Date: May 19, 2005
To: Josef Chalot, Archetype, P.A.
Fax #: 772-4076
Prom: David Tetreault
Subject: 107 Pine Street

I have reviewed calculations for structural members at the subject project and have determined the following:

Here **are** the revised plans for the **garage addition** at 107 Pine Street. The revisions are according to **your** conversation with David **Lloyd**. All the changes have been bubbled on the **drawings**. We've called for **gypsum wall board** on the ceiling and walls of the **garage**. The structure of the roof/deck and parapet wall **has** been **clarified** and approved by **our** engineer **in an** attached letter. ~~Please~~ let me **know if** you have **any questions**.

2 ROOF DECK FRAMING PLAN
1/4" = 1'-0"

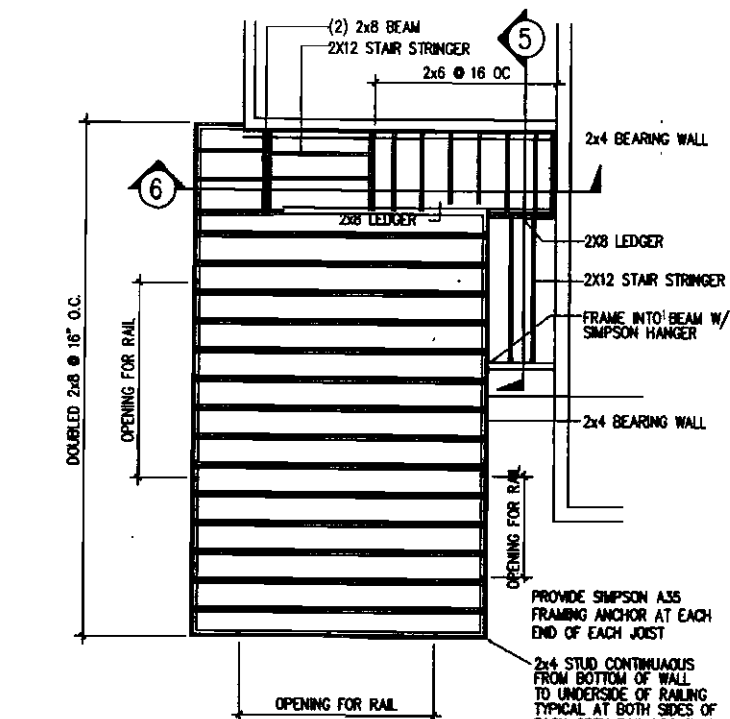
The (2)2x8 @ 16" roofrafters meet the requirements of IBC 2003. The rafters were checked for a 40 psf live load using a load duration factor of 1.0 and a 60 psf snow load with a load duration factor of 0.9. All stresses and deflections are within prescribed limits for both cases.

5 SECTION DETAIL
3/4" = 1'-0"

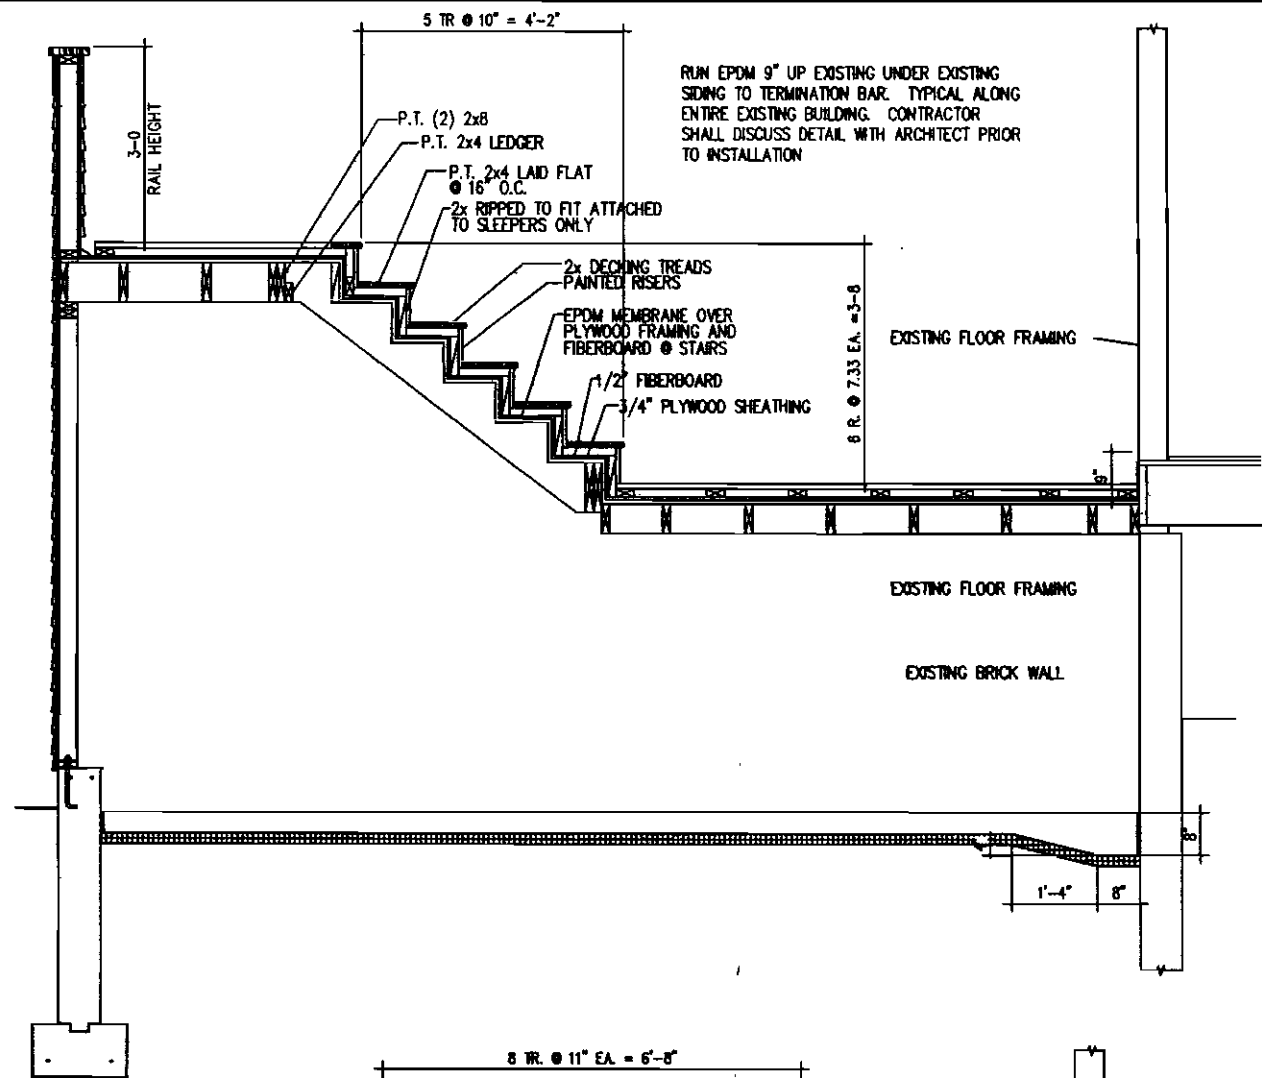
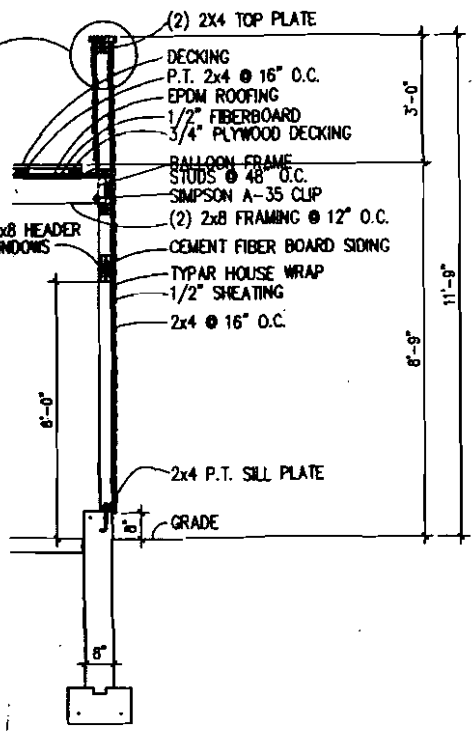
The parapet wall should be framed with 2x4 @ 16". The parapet wall studs should be fastened to the roof rafters with (4) 16d nails and to the double plate of the bearing-wall below with a Simpson A35 framing anchor. The exterior sheathing should be continuous from the bearing-wall below. The continuous rim joist should be eliminated and replaced with 2x8 solid blocking between each rafter/stud (see below)
